Single storey extensions to residential property - Resubmission following planning application P/47/11.

52 East Front Road Pagham

Thank you for your internet representation made on 29th November 2011 which has been recorded as **an objection** with the comments as follows:

Project	52 EAST FRONT ROAD, PAGHAM, BOGNOR REGIS WEST SUSSEX PO21 4ST	Drawn	sk	Project	126
For	Mr and Mrs Eysers	Scale	1:100 @ A3		
Title	SOUTH ELEVATION - PROPOSED 2011	Date	25.10.2011	Revision	d
				Drawing No.	P 06

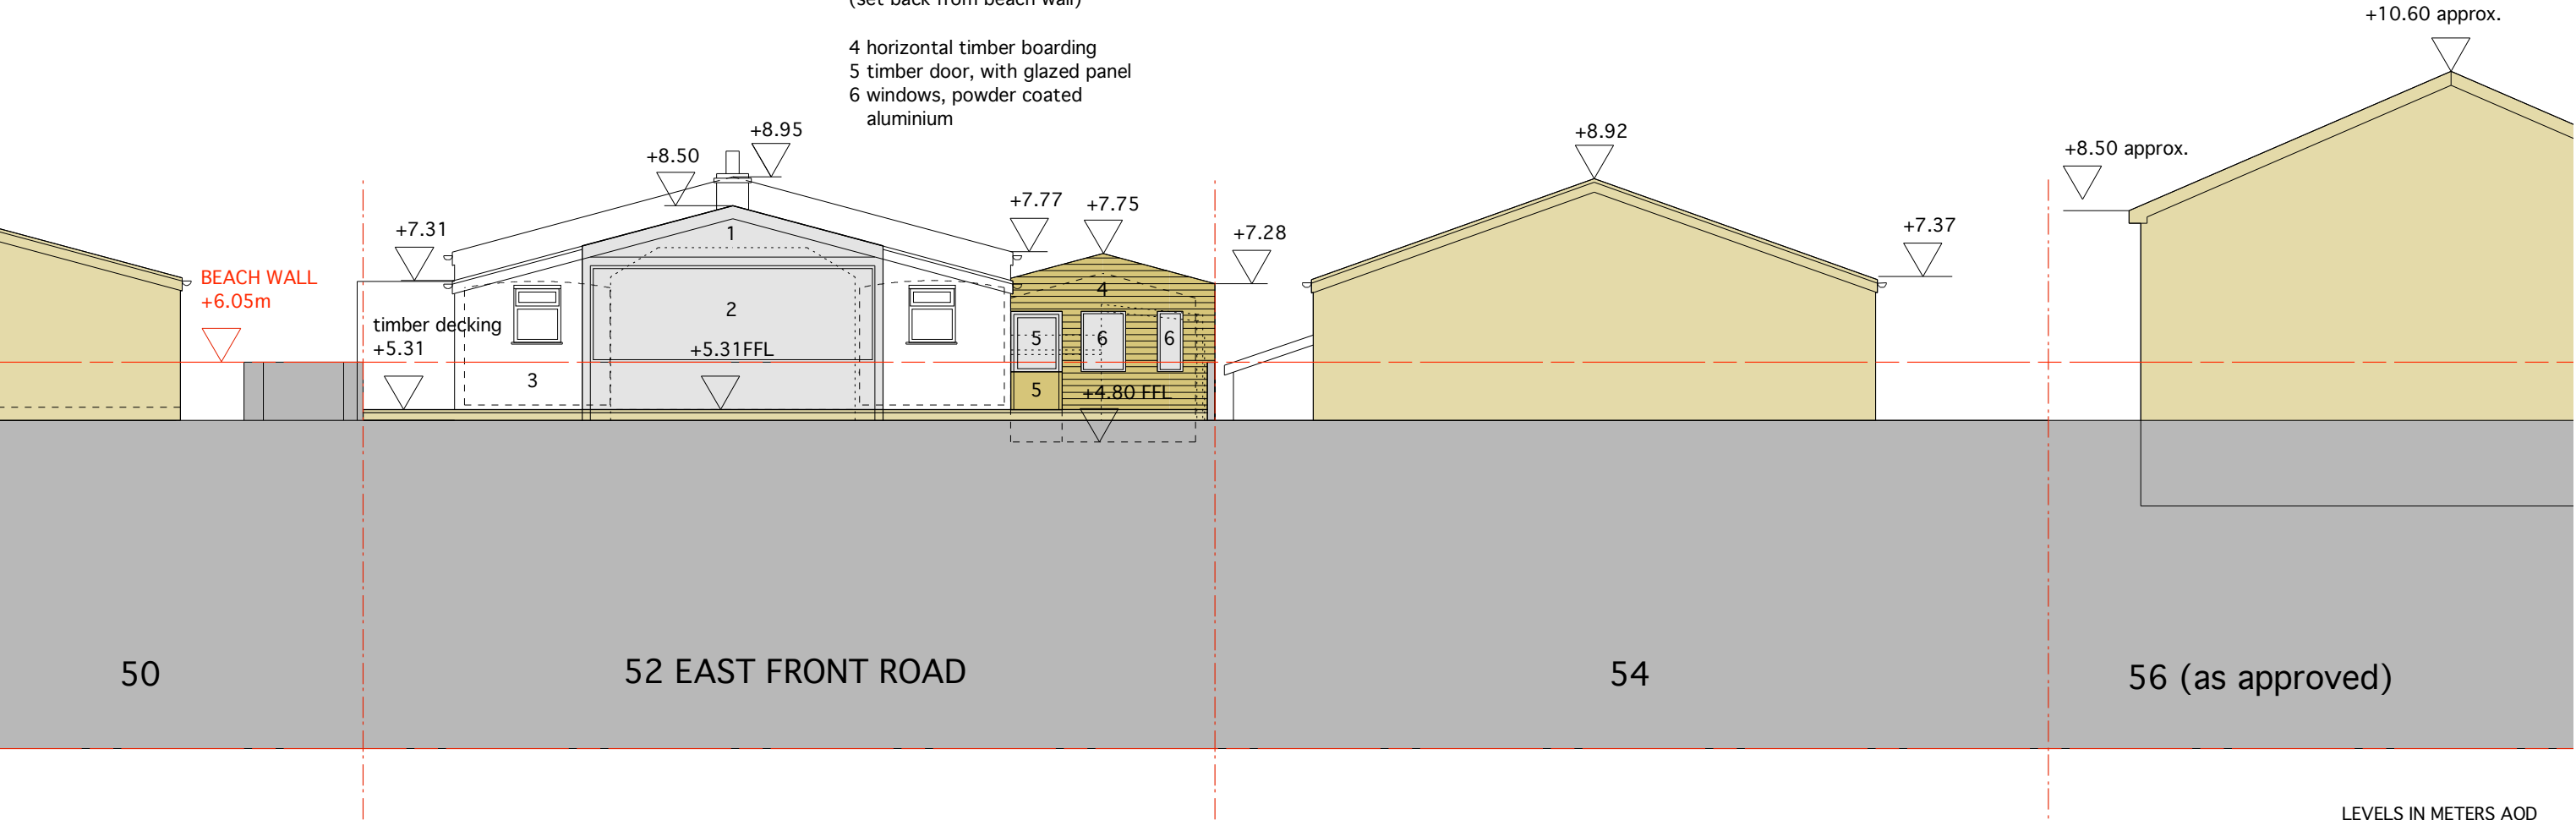
Members noted that the submission before them included various amendments to the previous application, (P/47/11/), in order to address those features which had been subject to objection (hence refusal of consent). These were matters relating to height and bulk of the proposed development, subservience of the garden extension, and amendments to fenestration, (most particularly, roof lights). These were felt to be positive changes, and were duly commended.. ☐

Project	52 EAST FRONT ROAD, PAGHAM, BOGNOR REGIS WEST SUSSEX PO21 4ST	Drawn	sk	Project	126
For	Mr and Mrs Eysers	Scale	1:100 @ A3		
Title	EAST ELEVATION AND SECTION A-A - PROPOSED	Date	25.10.2011	Revision	d
					Drawing No. P 07

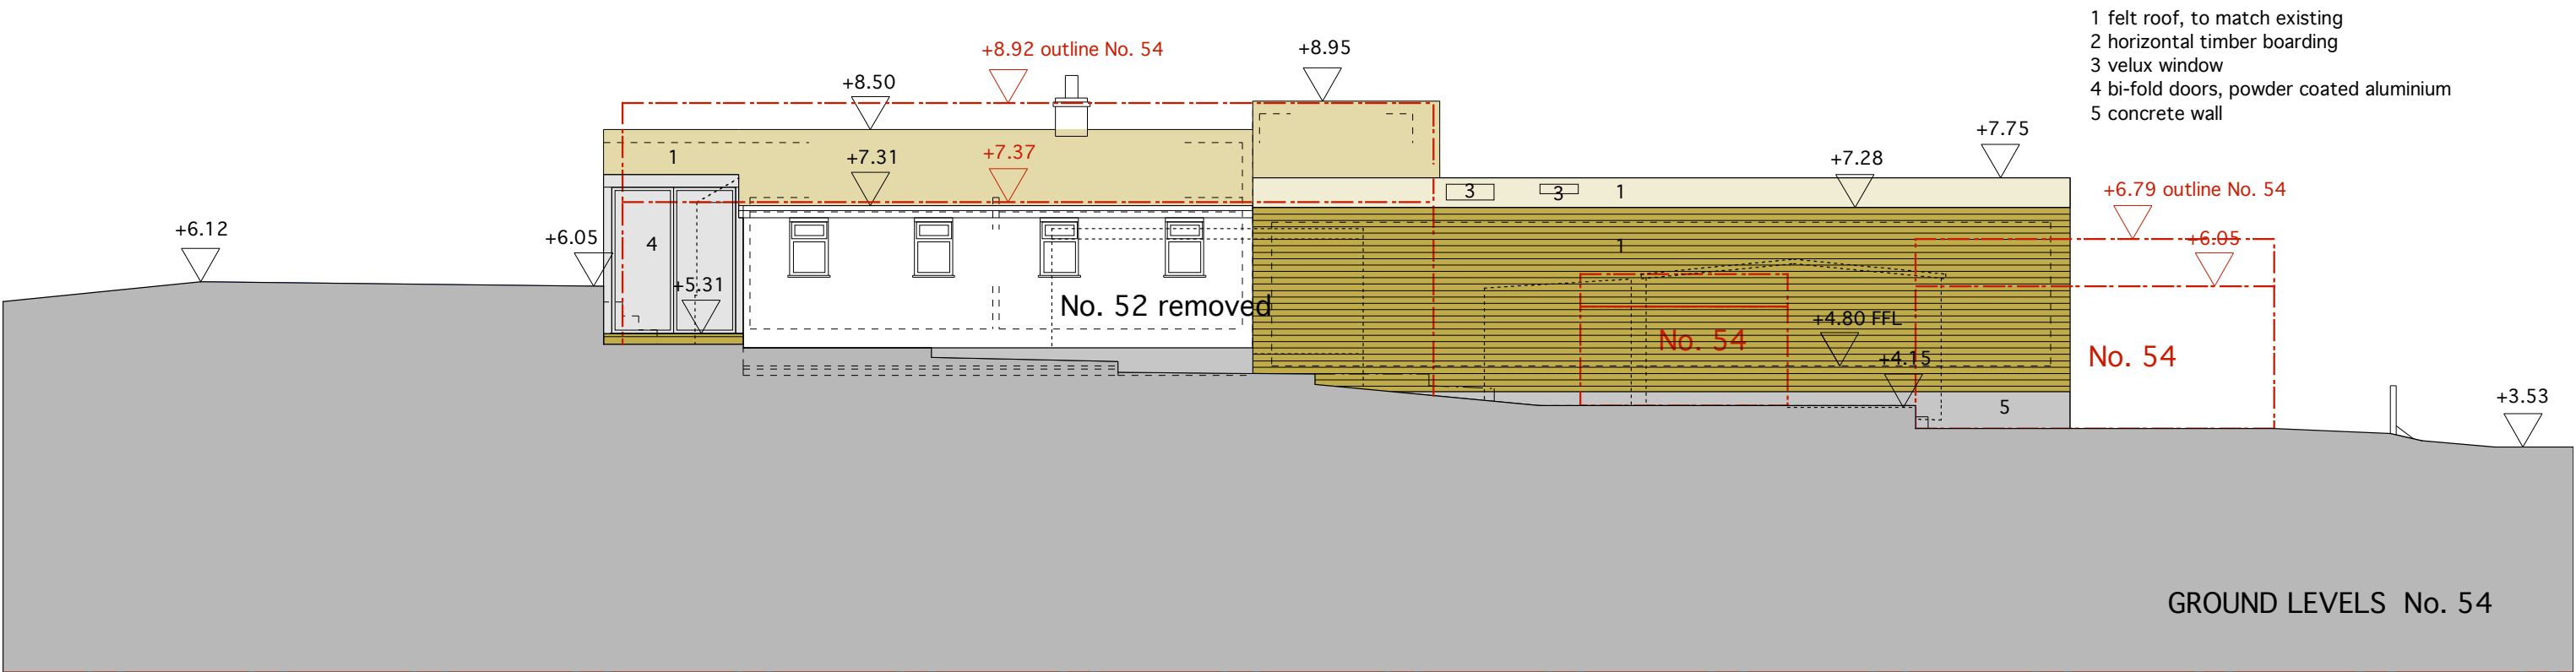
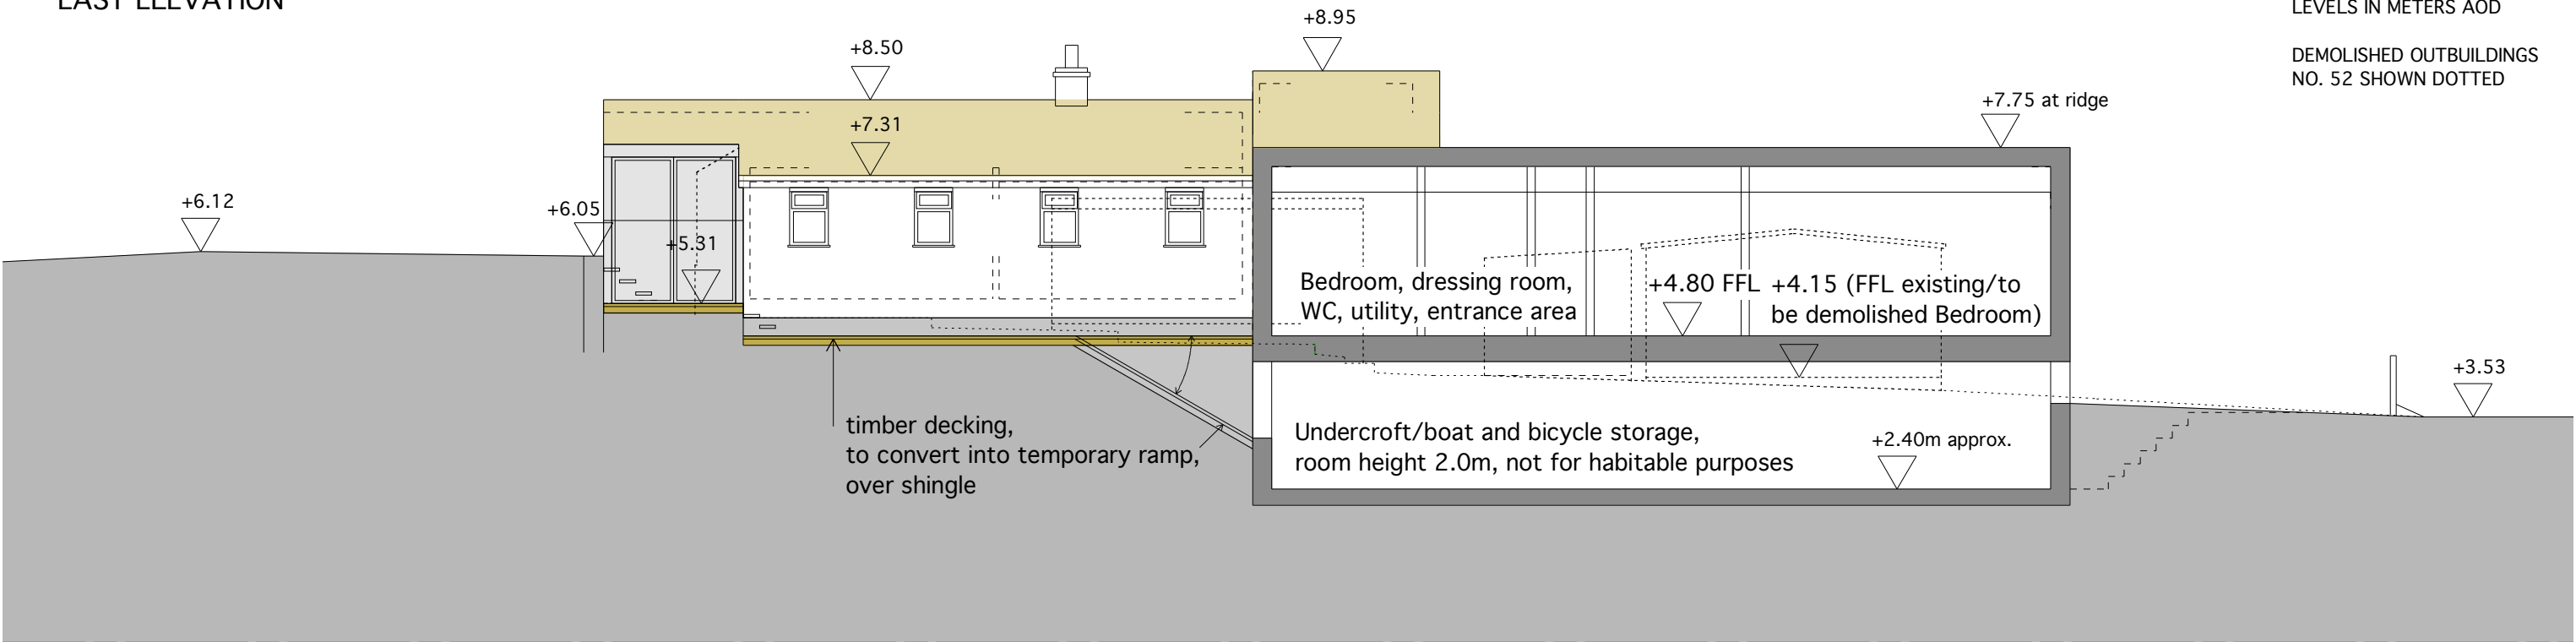
Of greatest concern, however, was the feature of this proposal which has been the subject of consistent objection by the Parish Council; which is the basement or undercroft component of the dwelling. Whether likely to be controlled by conditions in respect of construction and use, it was nevertheless felt to provide a worrying precedent which could lead to a range of irregular developments on the Area of Special Character, (ASC). ☐

The significant contour rise from East Front Road to the backshore crest from 3.8 AOD to 6.1 AOD dictates that the undercroft will be the subject of very substantial excavation, raising concerns in respect of ground stability and effects upon adjacent buildings. In this respect the Parish Council is aware of concerns of the Residents Association and the major landowner, Pagham Beach Holdings Ltd. ☐

Having regard to the comparative narrowness of the vegetated (SSSI) backshore at this location, it was felt that potential overtopping in the event of storm-surge, would seriously prejudice both the proposed dwelling, and ground stability adjacent. ☐
